The British Horse Society

Planning Inspectorate

21 Nov. 24

Oaklands Solar Farm proposal

- NOTE:
1. ALL DRAWINGS ARE TO BE READ IN CONJUNCTION WITH THE SPECIFICATION FOR HIGHWAY WORKS AND THE TURBINE MANUFACTURERS STANDARDS AND ALL RELEVANT DRAWINGS WITHIN THE PROJECT DESIGN PACKAGE.

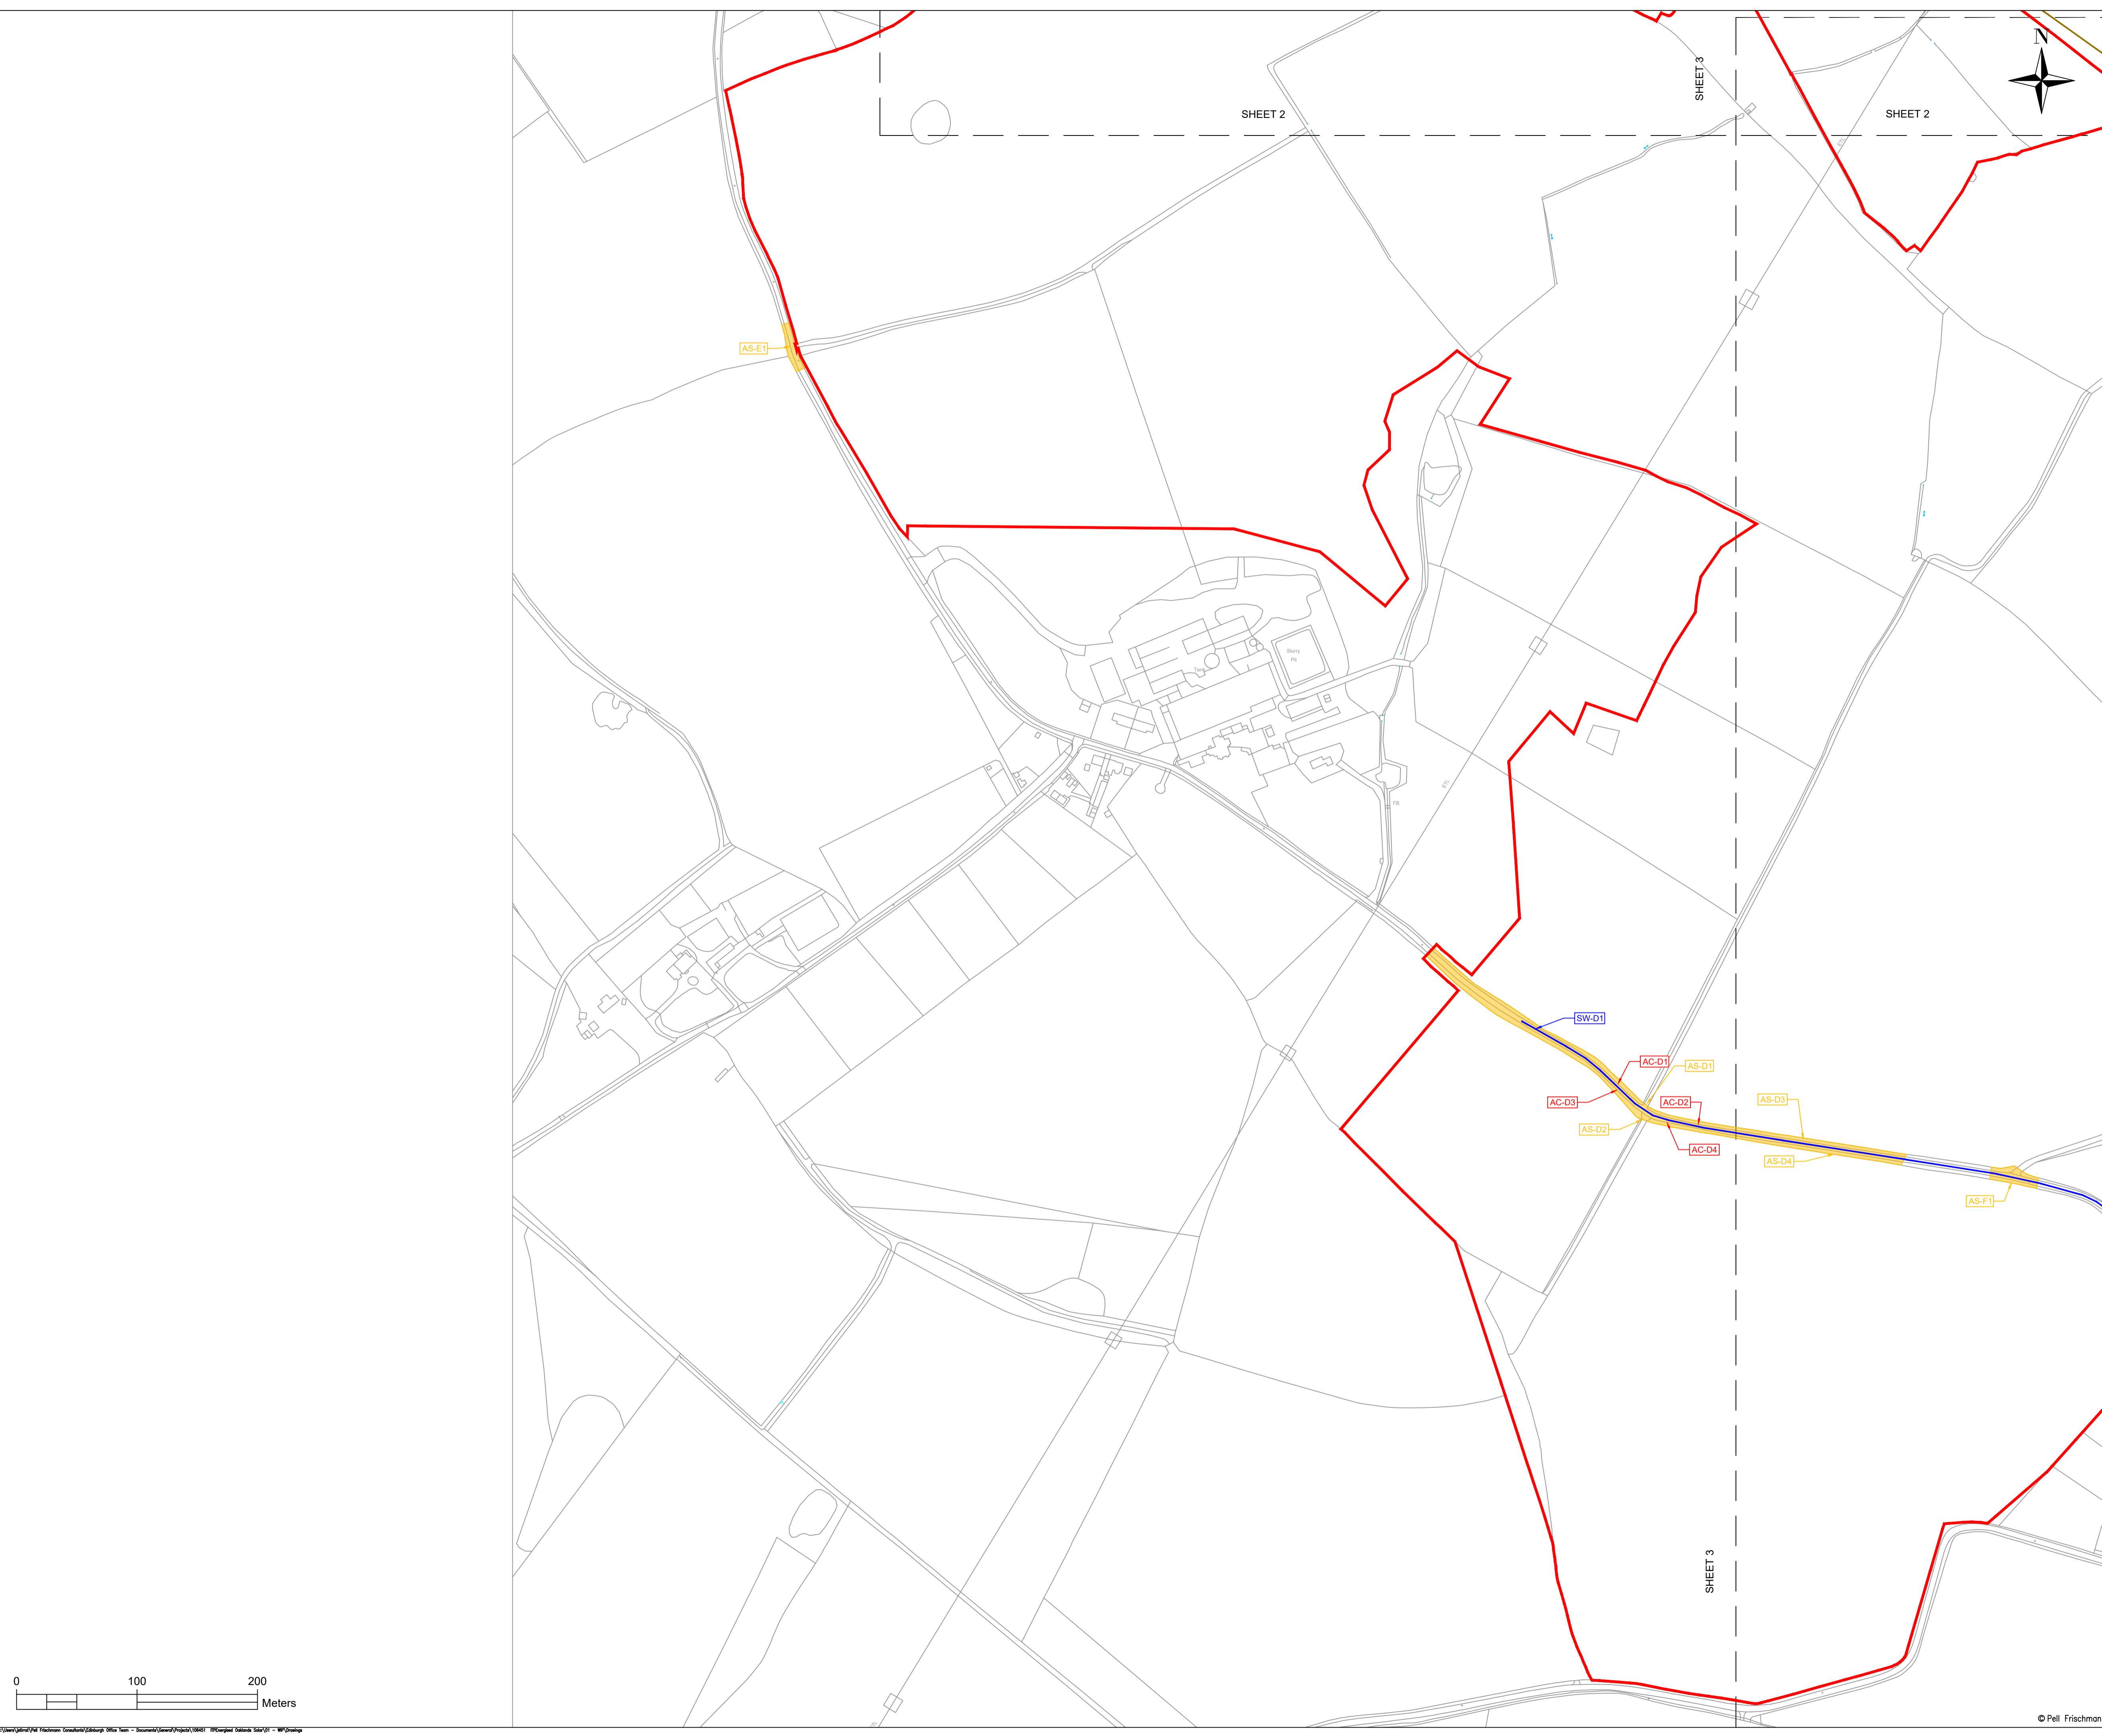
- It was discussed with the Project Lead in 2022, that equestrian access to the proposed permissive routes and permissive bridleways using existing footpaths (Walton Upon Trent FP9, Drakelow FP 5) for the life of the project would contribute to the community and provide off-road access for all vulnerable road users. However, the feedback from consultation does not appear to include any other vulnerable road users other than pedestrians. The dimensions proposed to buffer permissive and public rights of way would provide ample space for shared use.

Figure 2-1: Construction vehicle profile

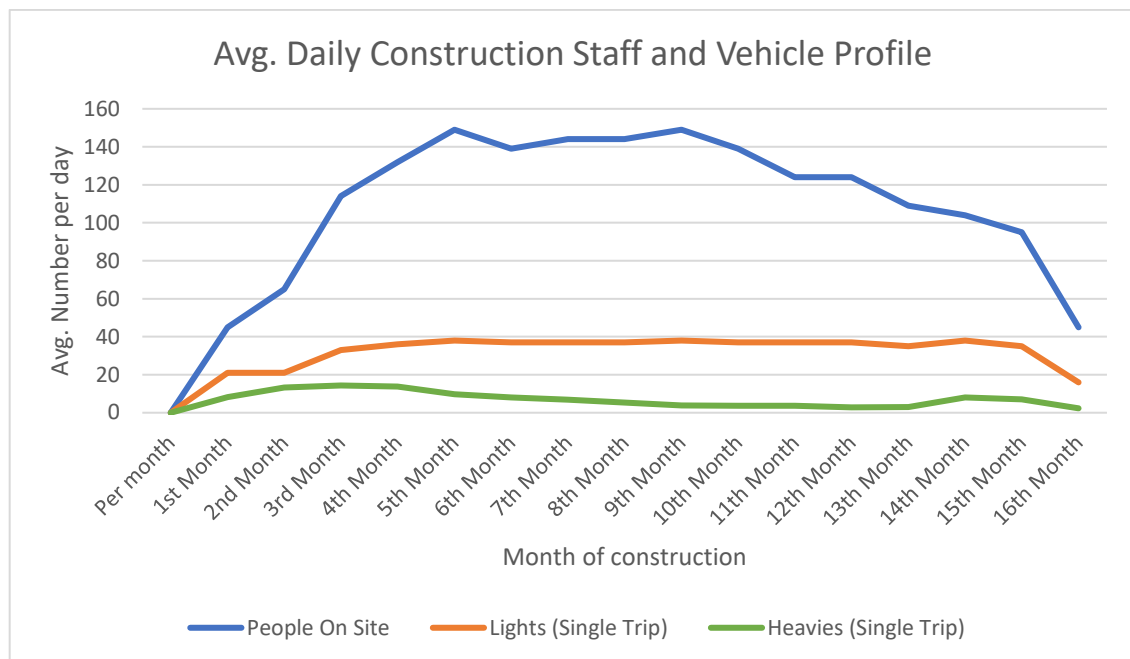
- The 16 month construction period with an estimated 13 HGV return journeys per day at the height of the construction period will impact on the volume of traffic on the road network locally. Already mainly 60mph roads with some sections of 30mph and 50mph, the additional traffic and the added complication

of vehicles regularly turning into the access road will make the road higher risk for vulnerable road users in the absence of speed restrictions or other traffic calming measures. Movement of the construction traffic may well coincide with times that equestrians are active on the bridleways and local highways network to reach the off-road routes. Notification of this to allow equestrians to choose to avoid the area on that day would be helpful.

Indicative Abnormal Load Swept Path Analysis

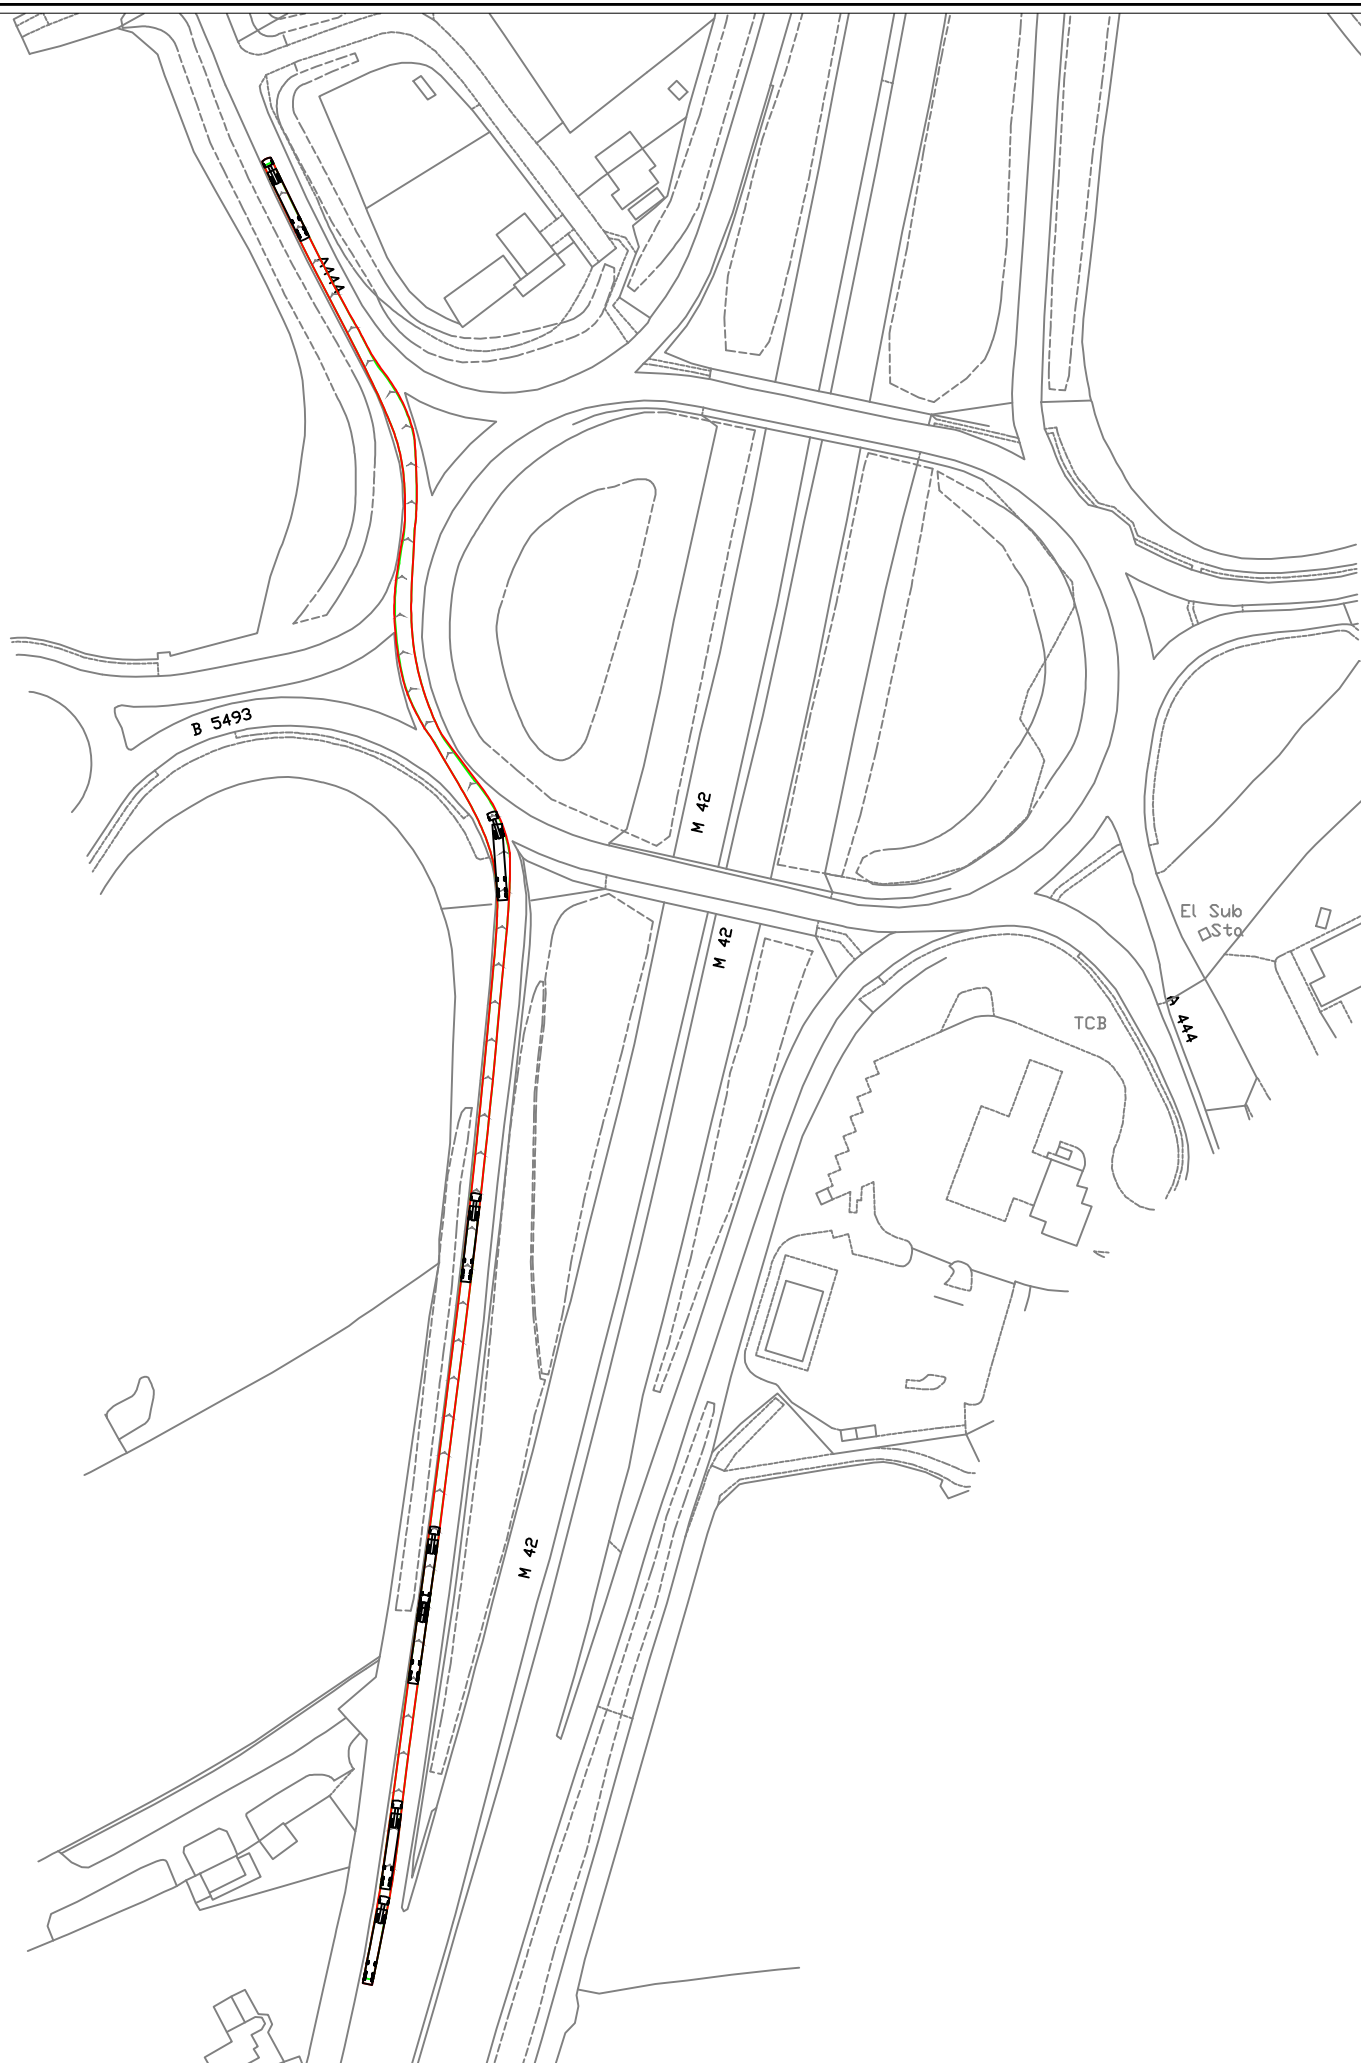
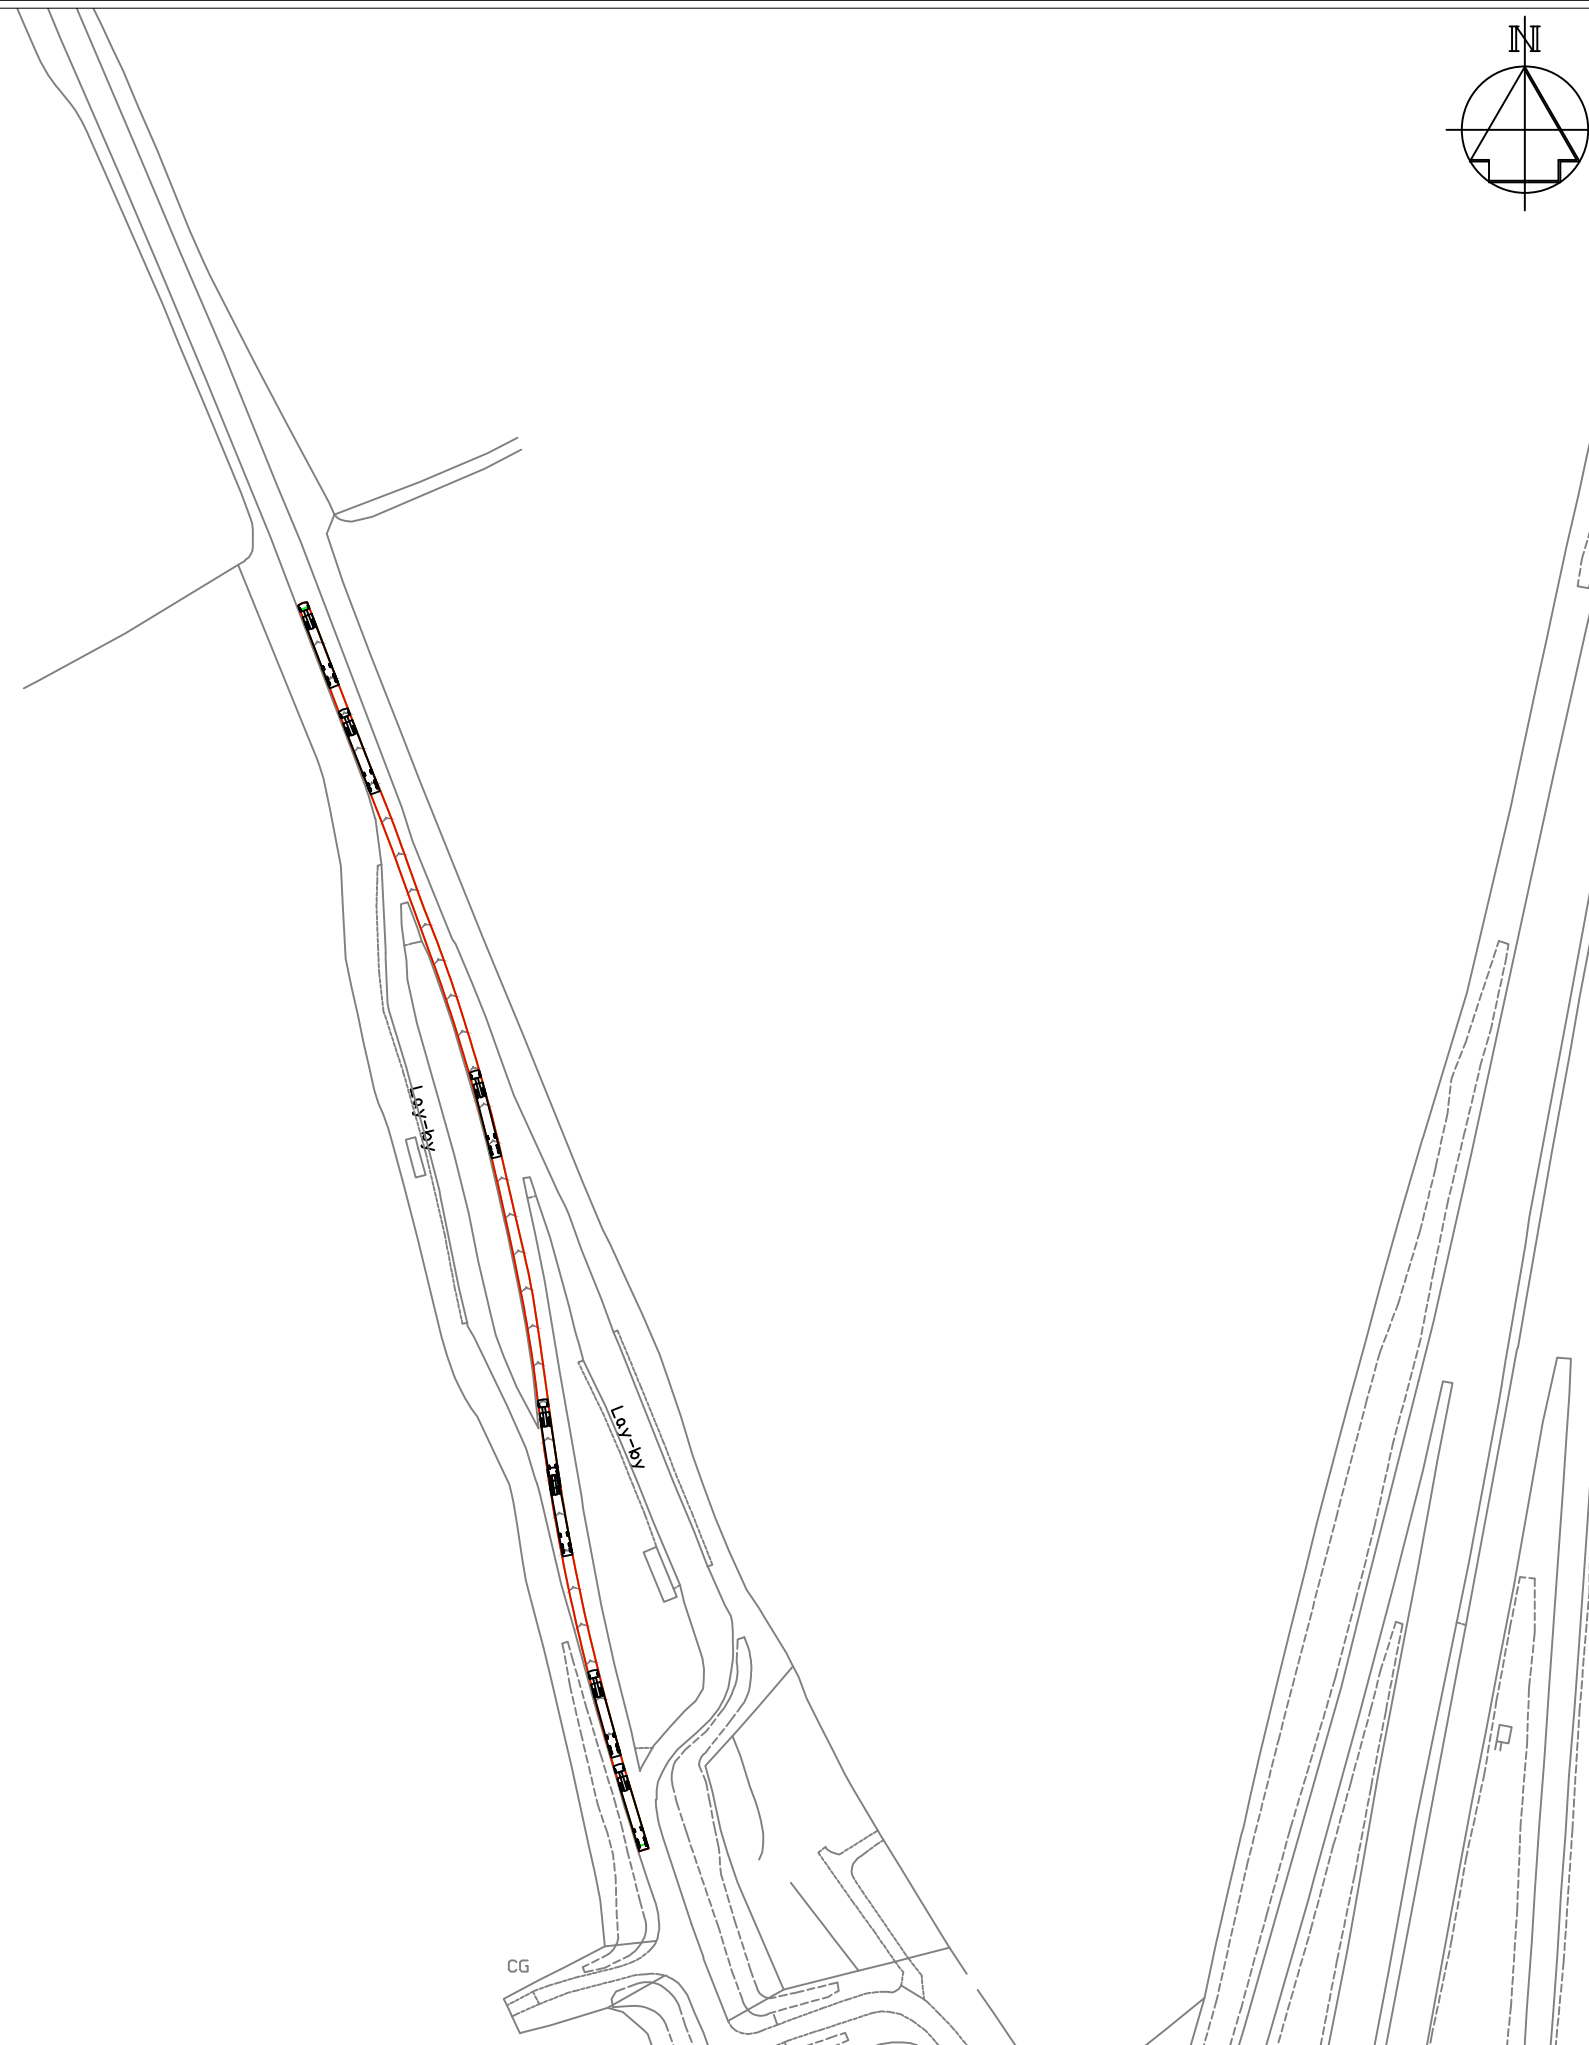
- An abnormal load is mentioned. Local riders are concerned that the abnormal load route would pass both Grangewood livery and Sealbrook livery yards. How will this be managed for safety?
